Cambridgeshire County Council

Sunnica Solar Energy Farm

Planning Inspectorate Reference: EN010106

Written Representations

MSTL551 - Sunnica Energy Farm Reporting Zone A  
 Figure A33 - XY Trace Plot (Area 7 West)  
 30nT/cm at 1:1,500 @ A3  
 Copyright Magnitude Surveys Ltd 2020  
 Contains Ordnance Survey data © Crown Copyright and database right 2020

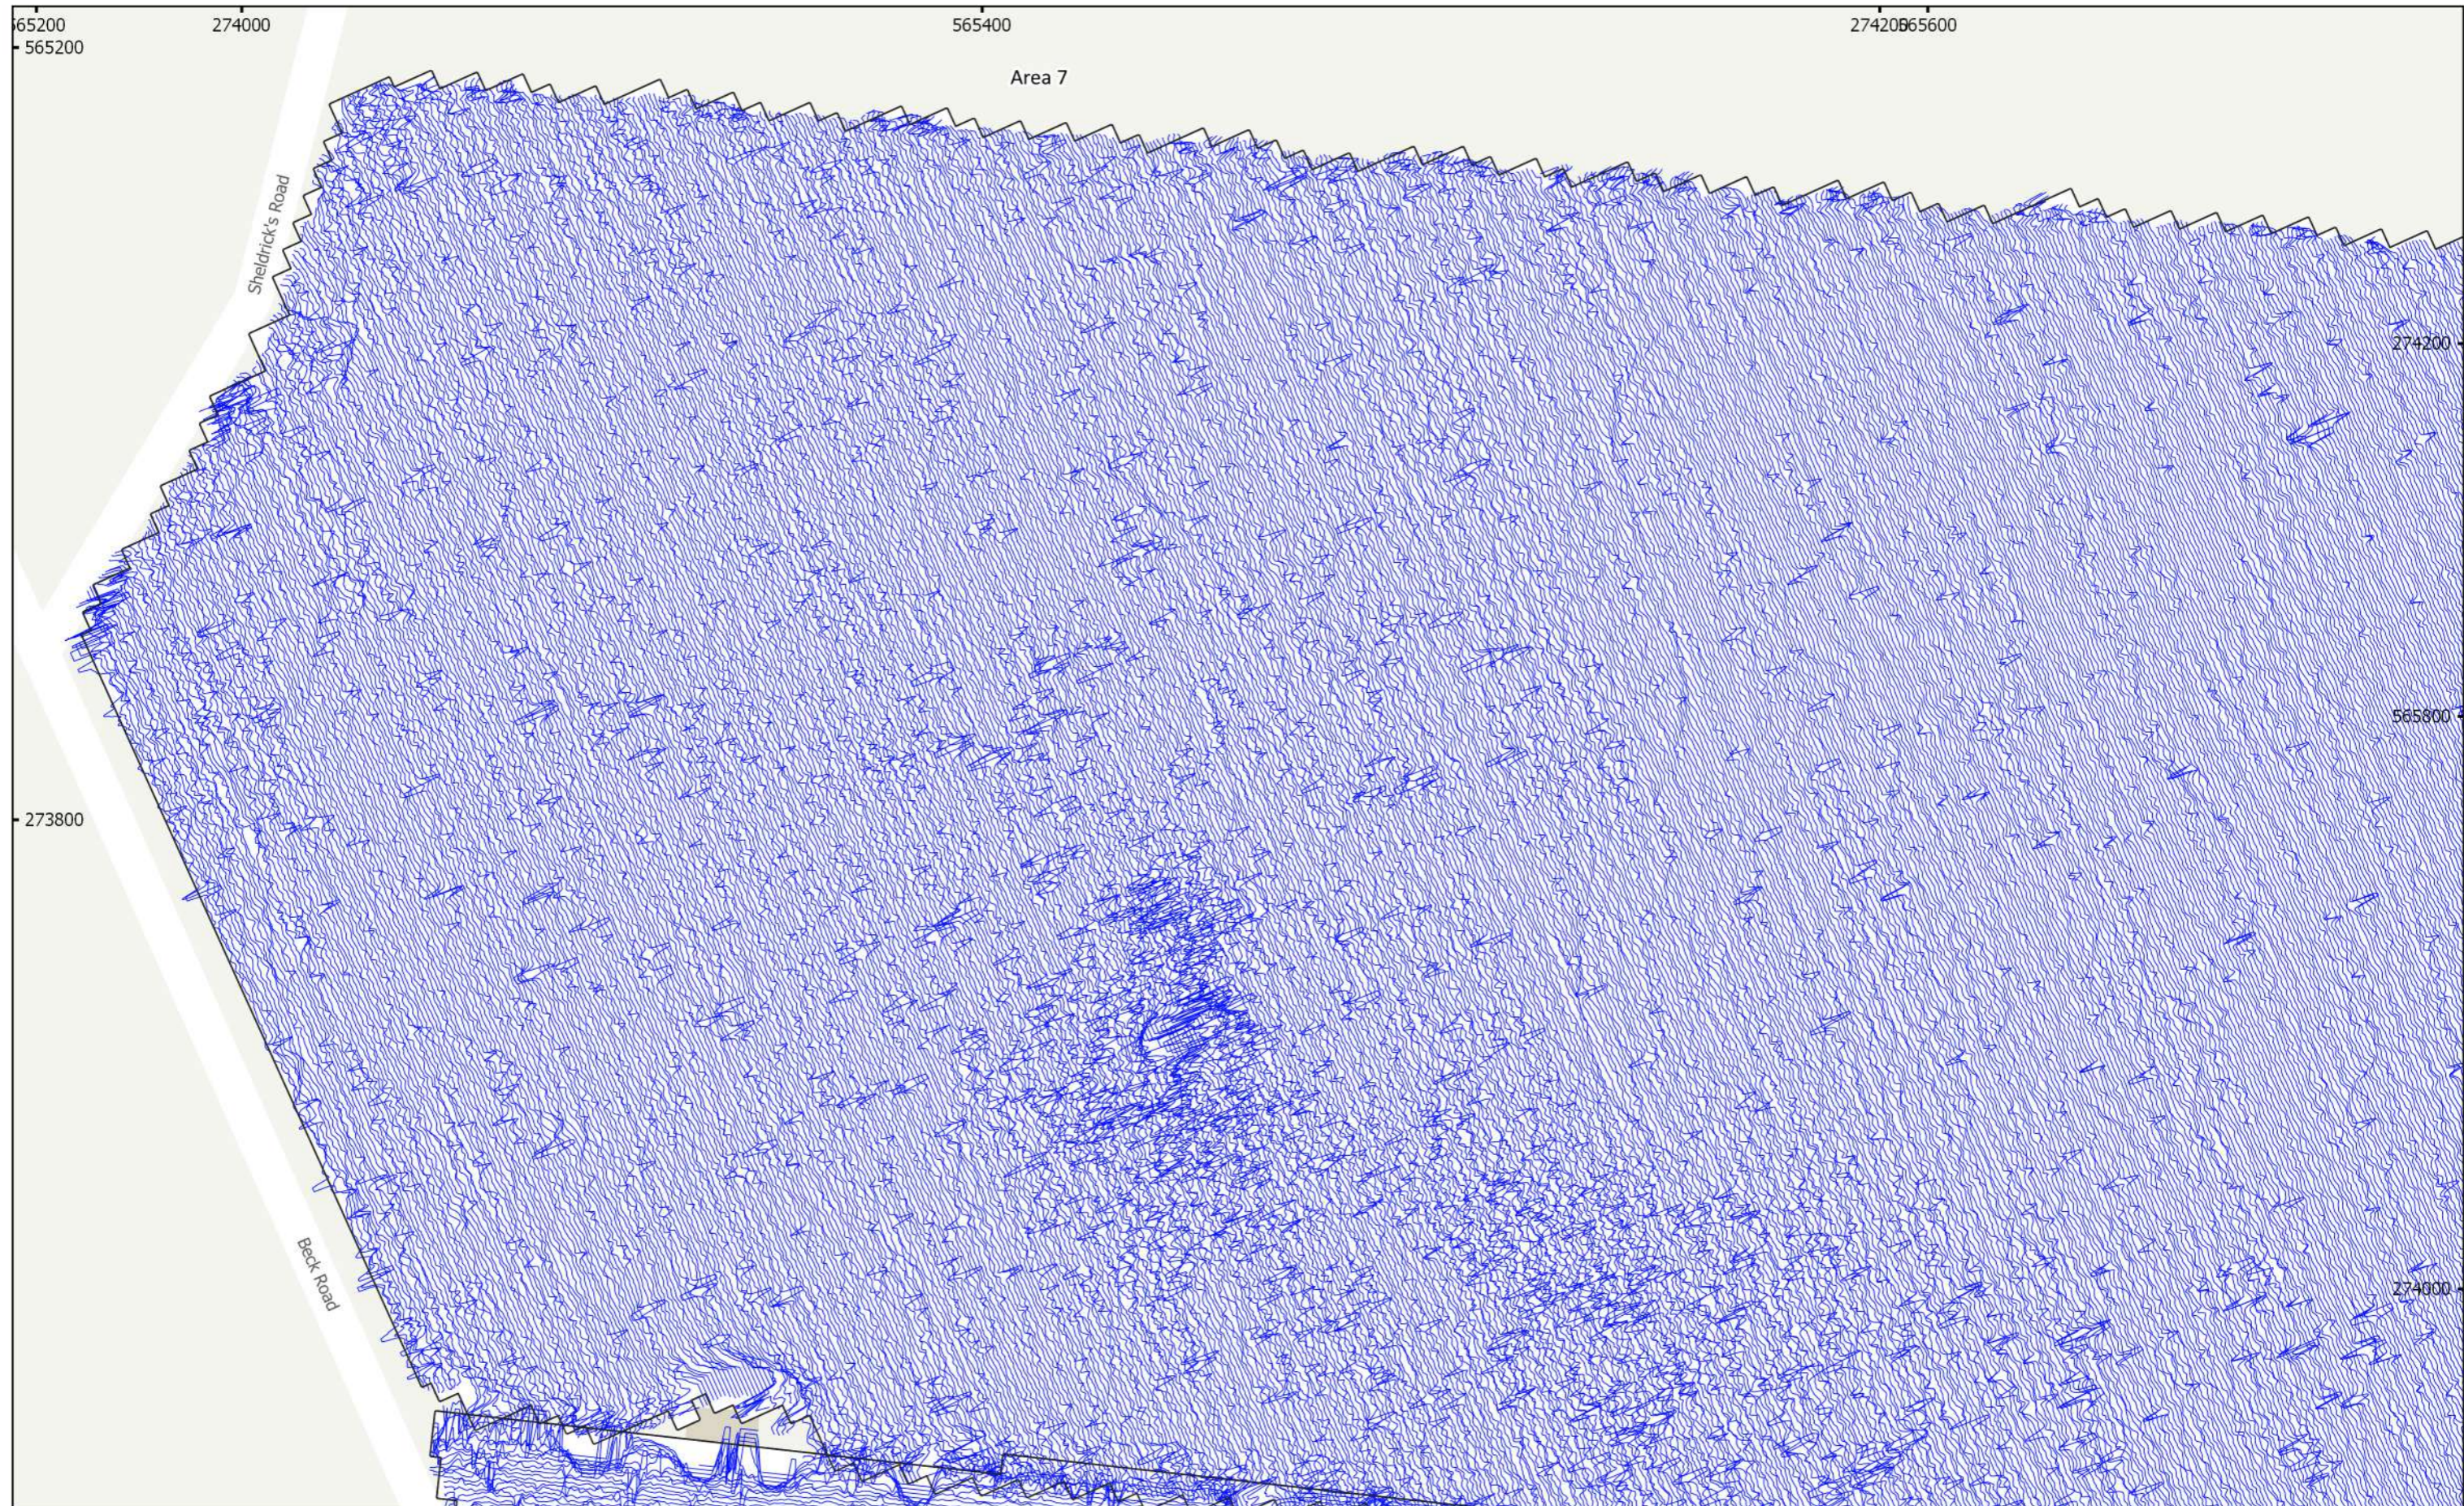
- 2.11 Geophysical Survey plots Figure A7-A9 and A33 (APP-063) show a strong dipolar anomaly, which in hindsight is the crash site (please see attachment 'Sunnica East E05 GS Zone A crash site'). Although it seems strange to have avoided it, the dipolar anomaly did not receive a test trench to check it due to a common assumption that the strong dipolar signal usually means the burial of farm rubbish and potentially contaminated land – all too often seen and often hazardous to deal with. Archaeologists do not deal with contaminated land issues and leave this to other professionals.

- 2.13 The councils consider that it would be inappropriate to develop the site of the crash with photovoltaic panels but that an agreed space around it be clear of panels, fenced, grassed, and a small memorial stone established to mark it instead. A path to the memorial from a proposed footpath to be developed at the western field boundary is another possibility for consideration in the design of the solar array.
